Your Ref: ACP-324164-26

Our Ref: SID-TN-2026-012

Proposed Strategic Infrastructure Development (SID): Renewable energy development Carrow Wind Farm which will include 14 no. wind turbines and associated infrastructure in the townlands of Carrow and adjacent townlands, Co. Tipperary, including underground cabling to connect to the proposed 110kV onsite substation, electrical cabling for 110kV grid connection to the existing Kilonan 110kV Substation, in the townlands of Kilonan and adjacent townlands, Co. Limerick, and all associated infrastructure and works in the townlands of Carrow and adjacent townlands with connection to Substation, in the townlands of Kilonan and adjacent townlands, County Limerick.

Outlined below are heritage-related observations/recommendations of the Department under the stated heading.

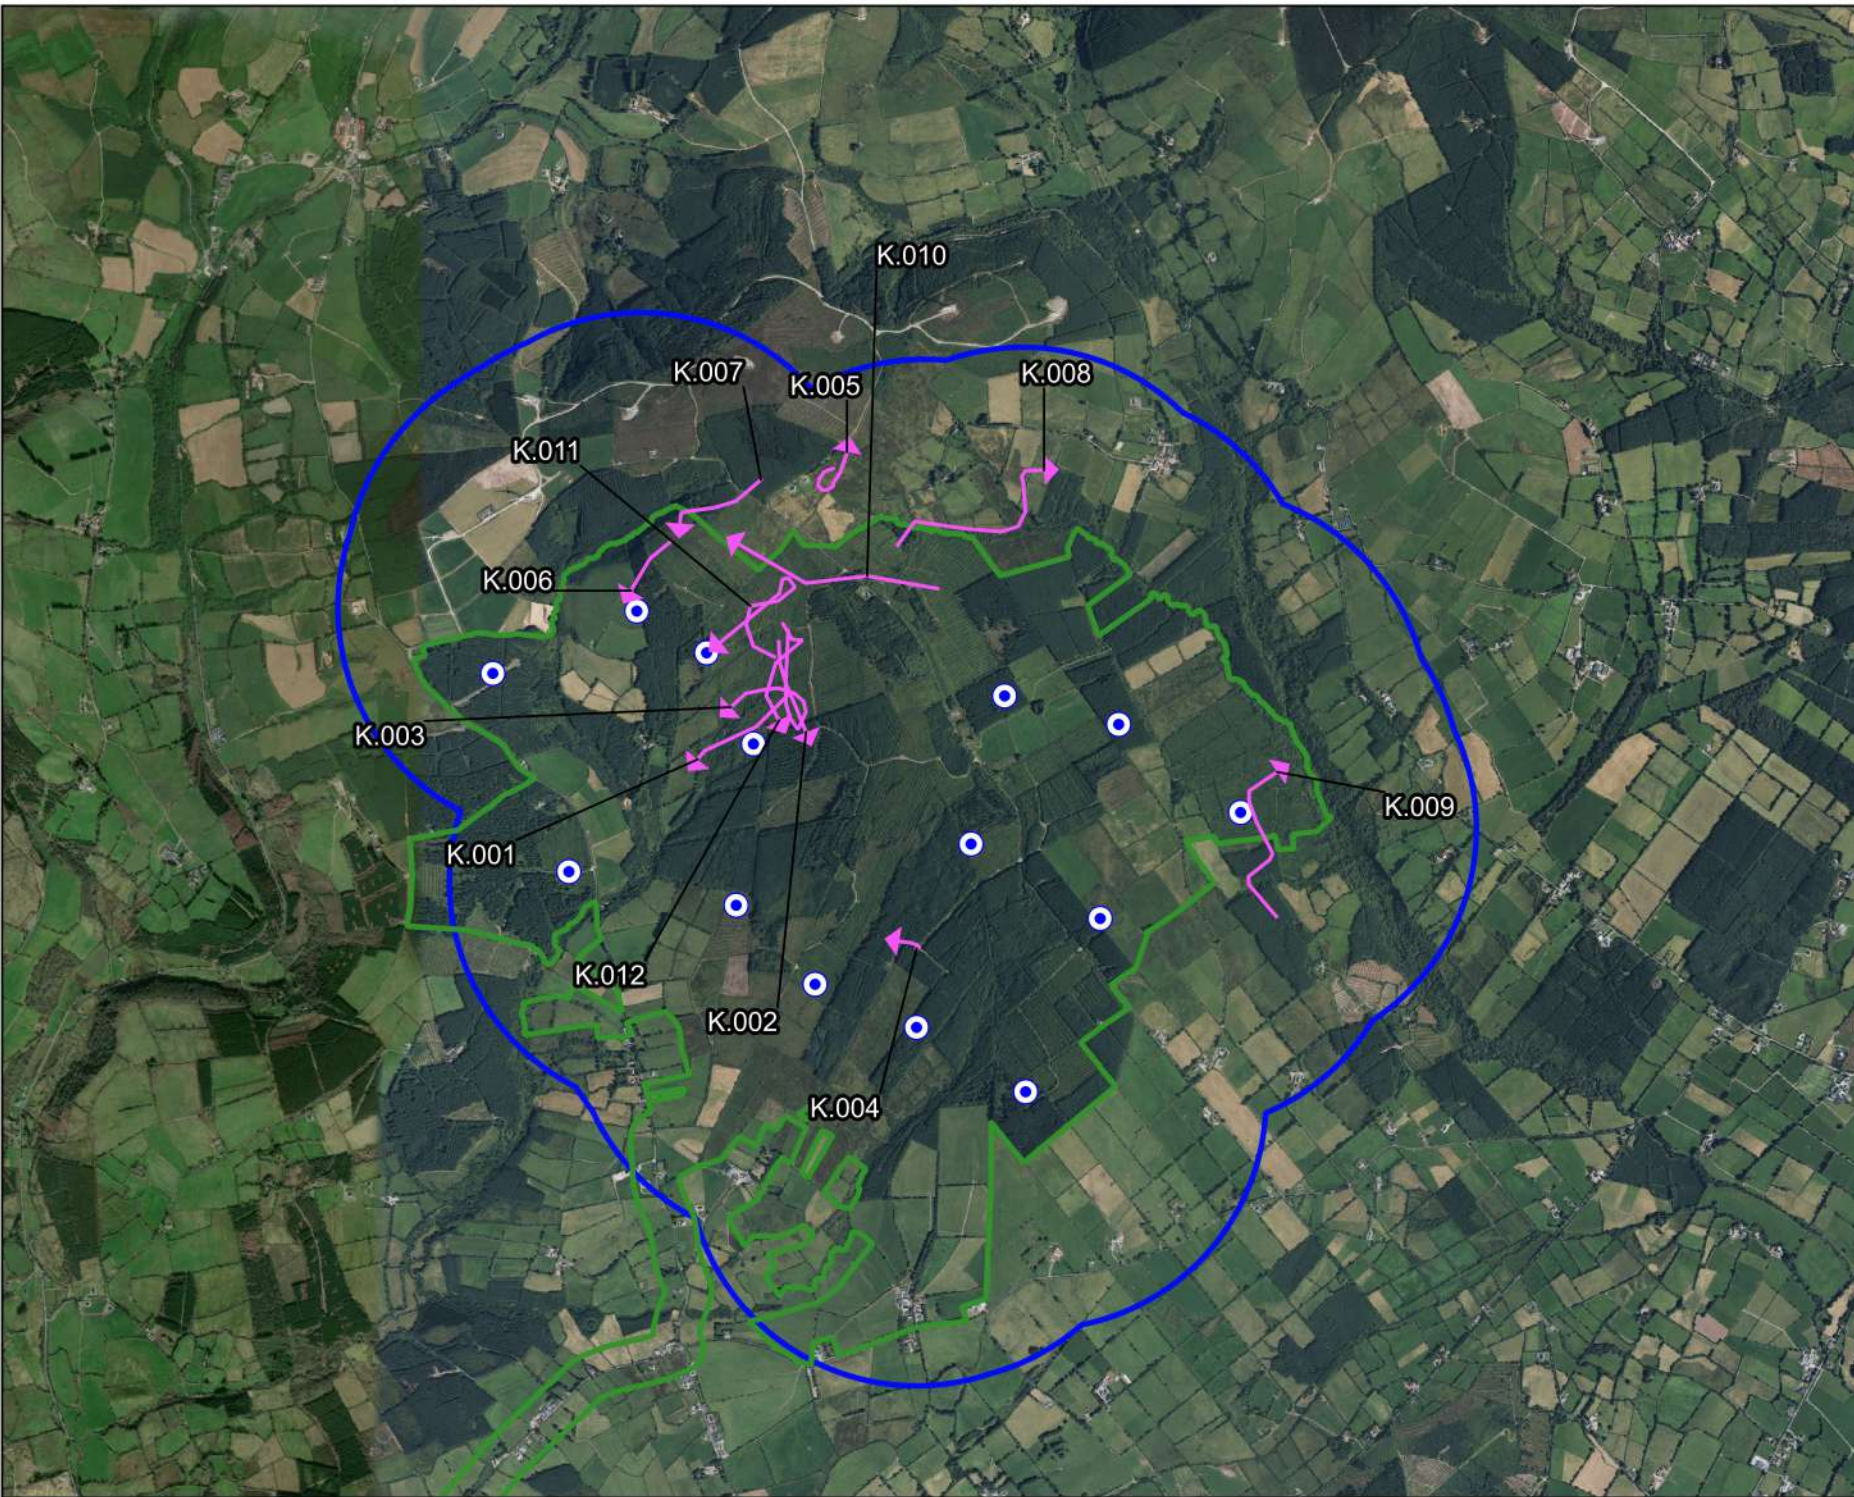
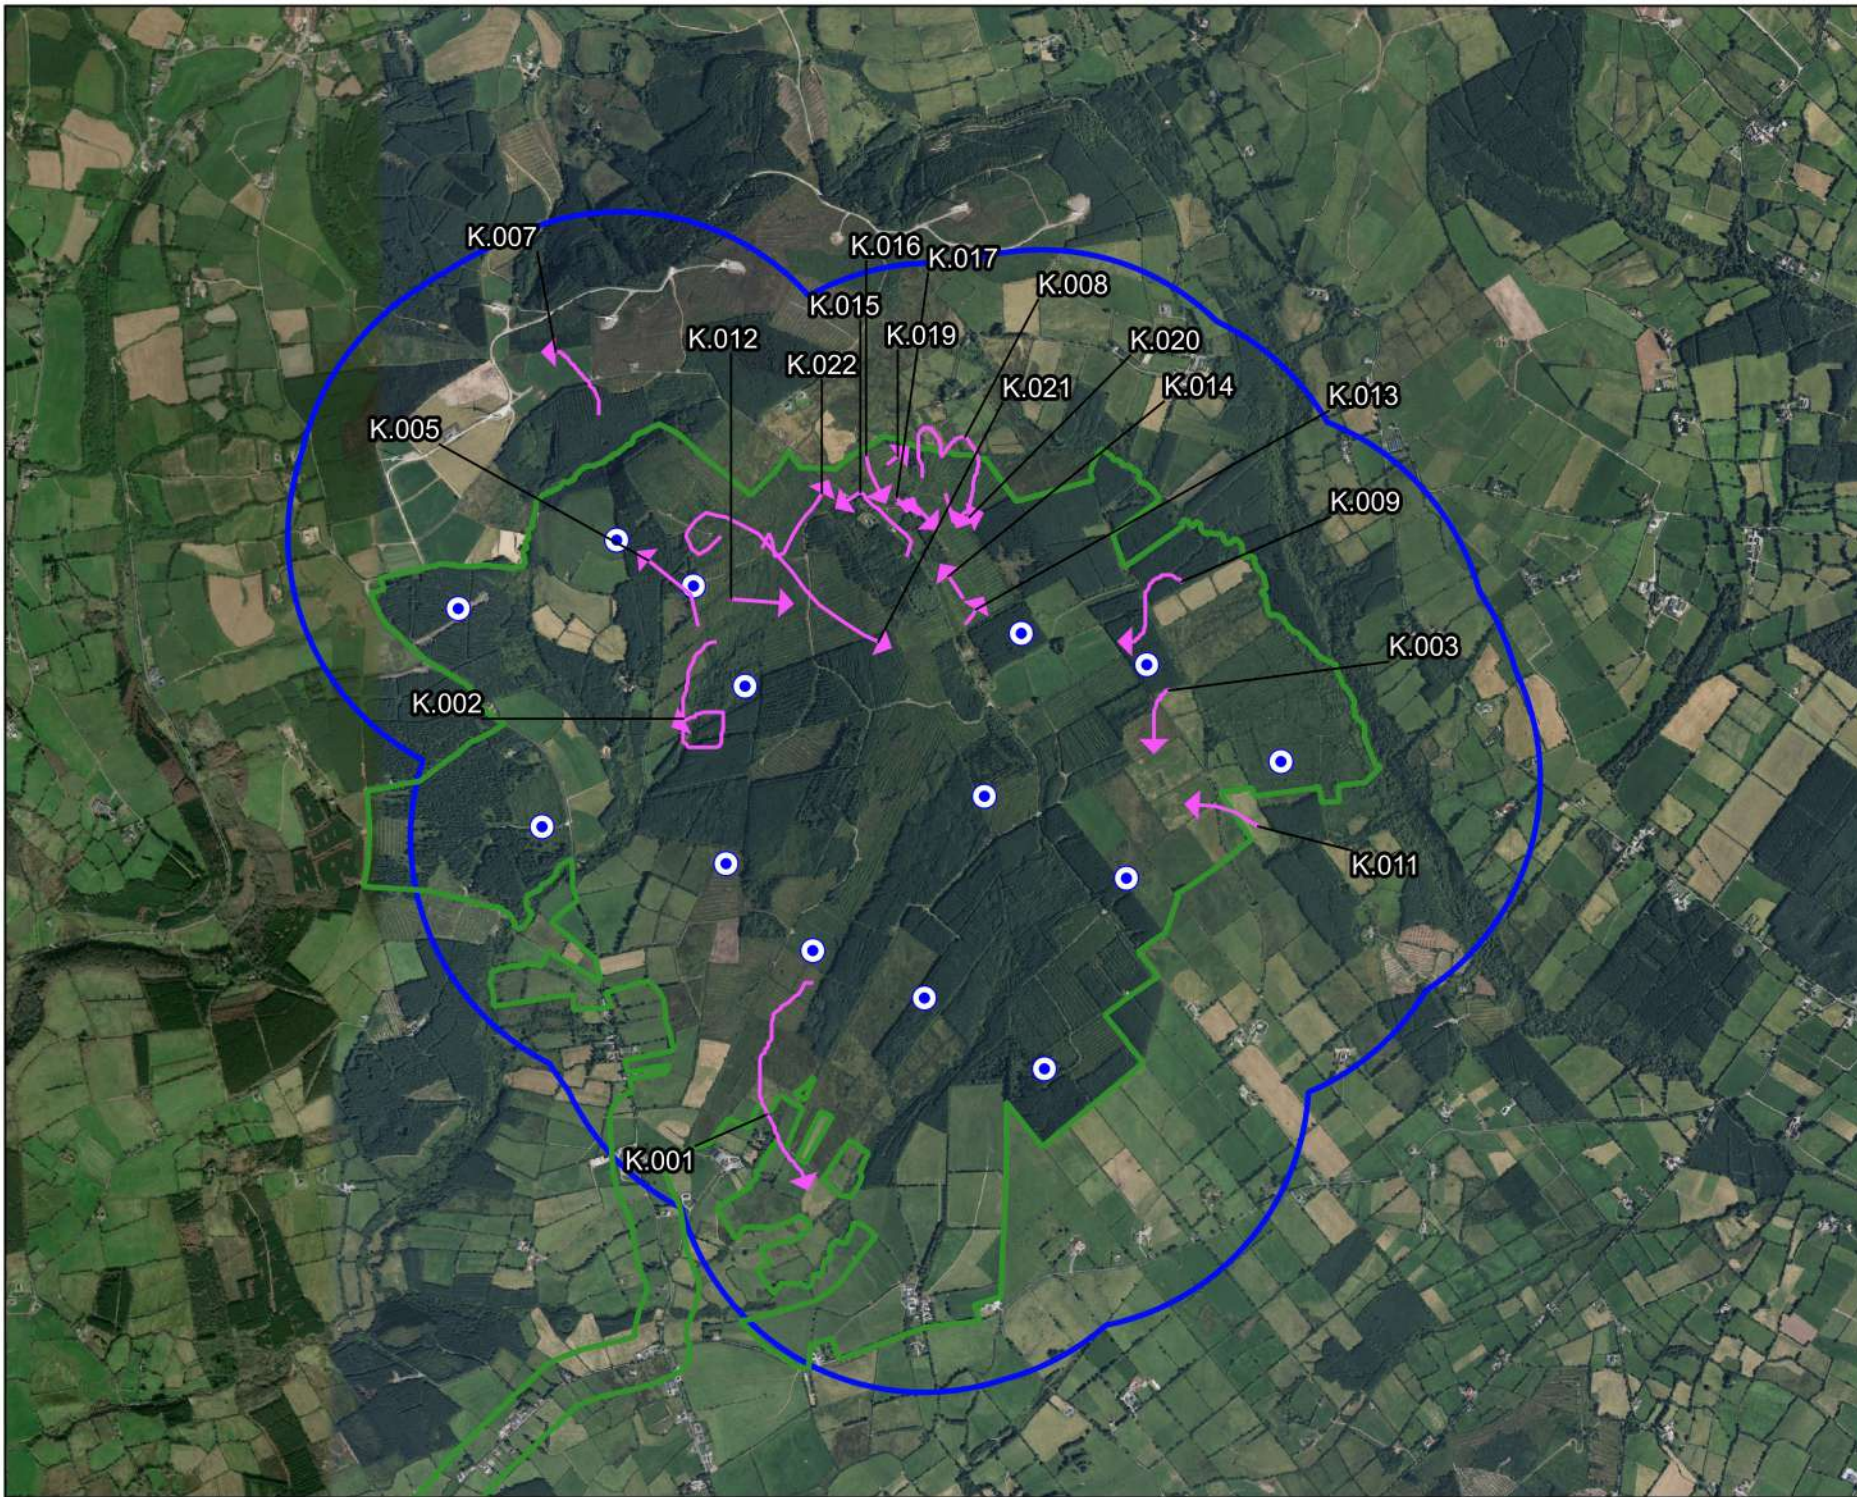
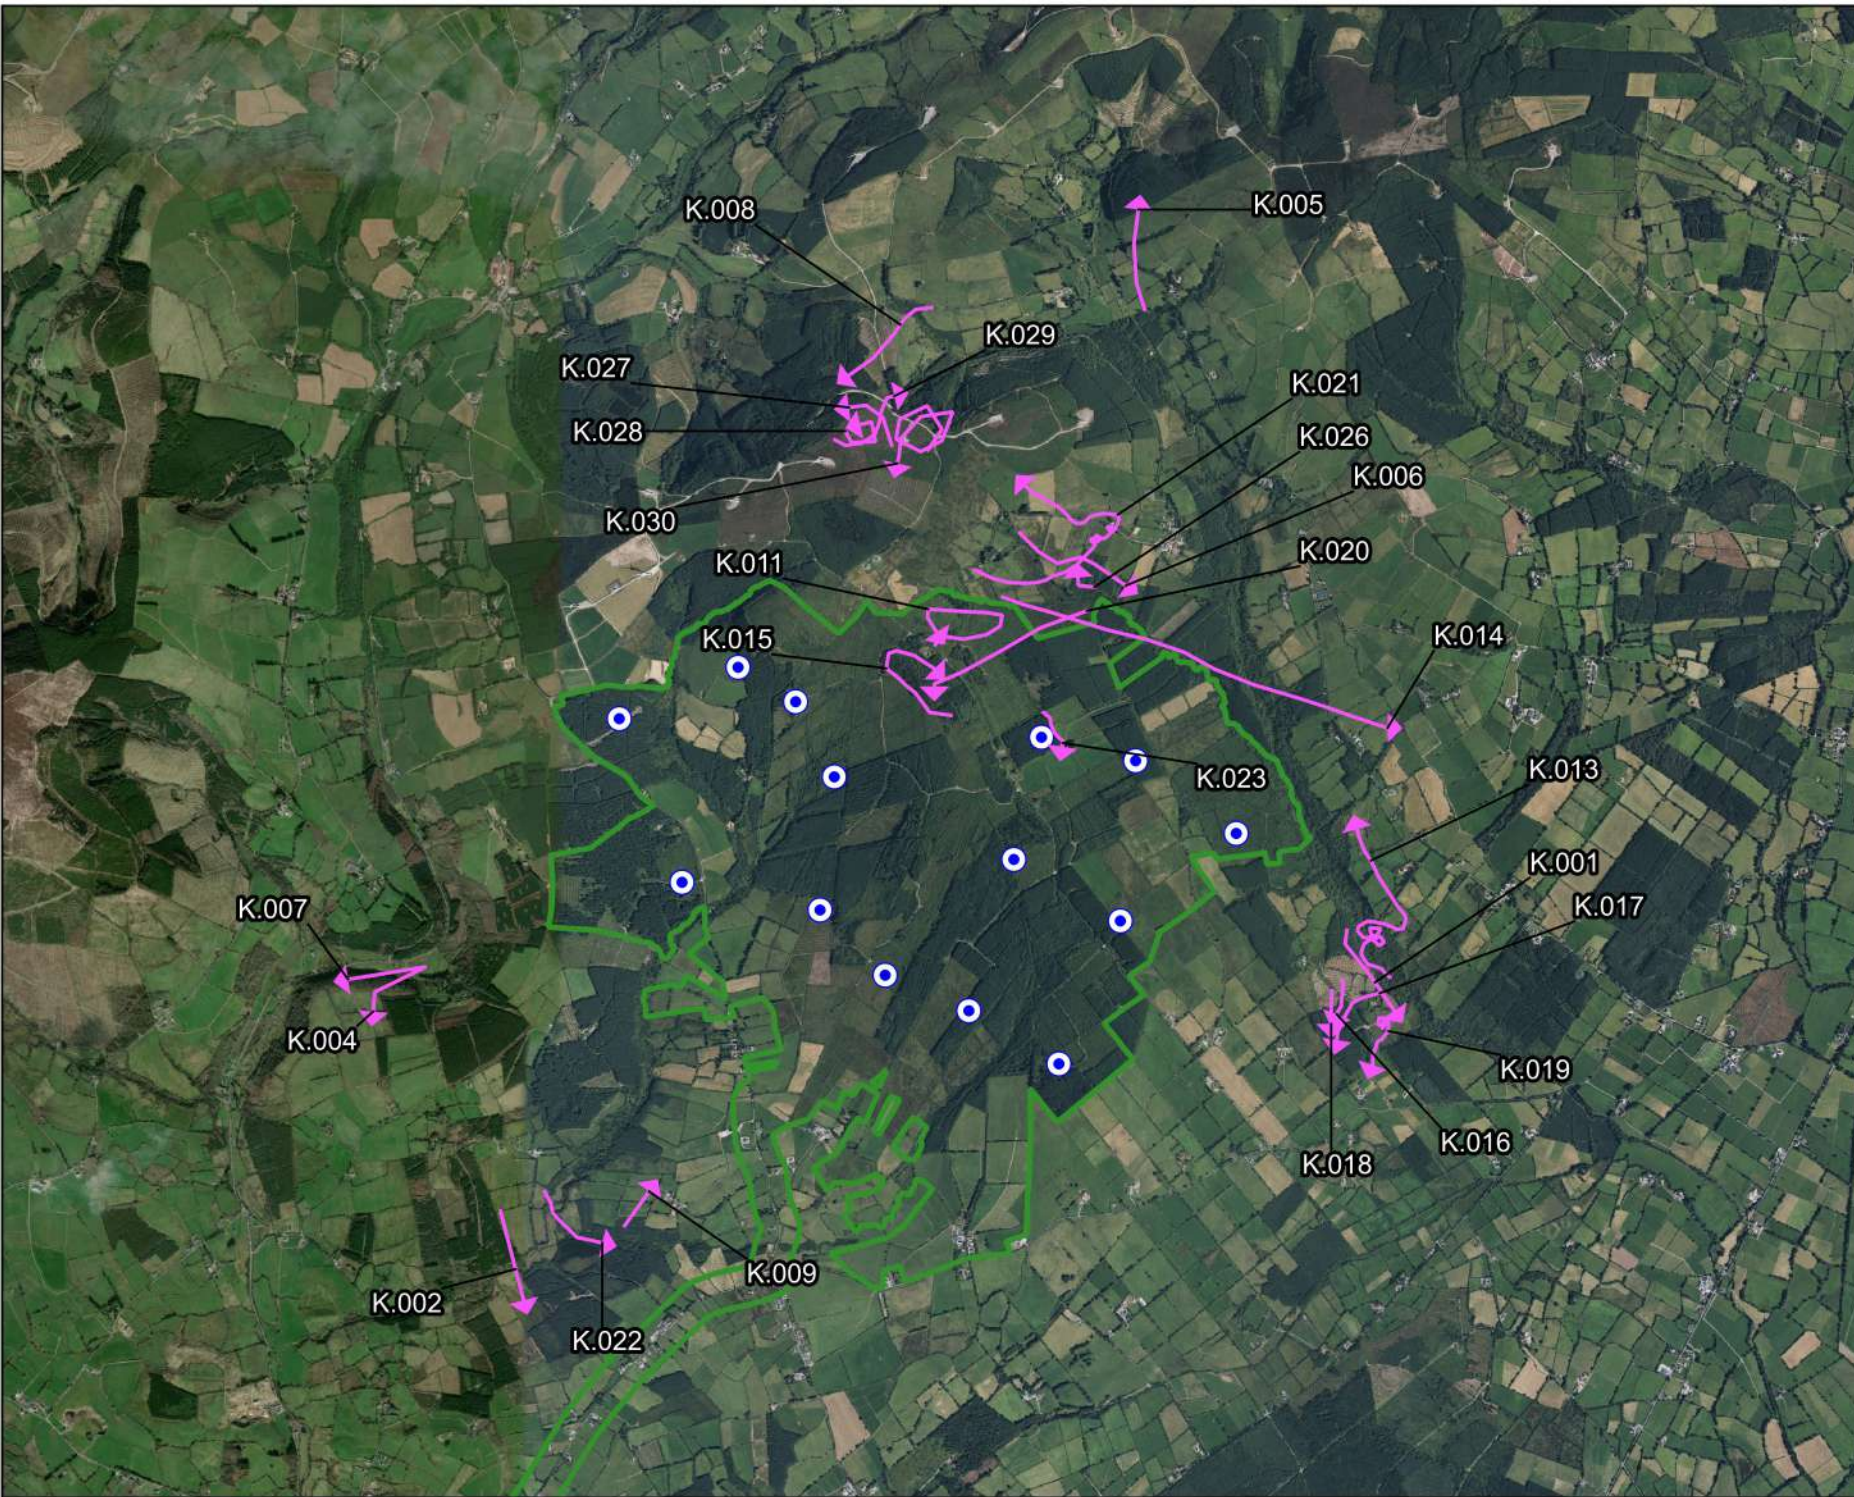
Four breeding Kestrel pairs have been observed on and adjacent to the proposed site, and Kestrels have been observed flying at rotor height. The collision risk has been estimated at 5.4 collisions per year. However, this has been assessed at county level as not significant. The Department considers that this collision risk at site level is highly significant and given that it is related to a breeding population, has implications for breeding success and recruitment, and could potentially lead to the loss of Kestrel as a breeding species from the locality.

The proposal to erect four Kestrel boxes along the site margins as an enhancement measure is also of concern, given the observed usage of the site by Kestrels breeding in adjacent areas, and the projected collision risk.
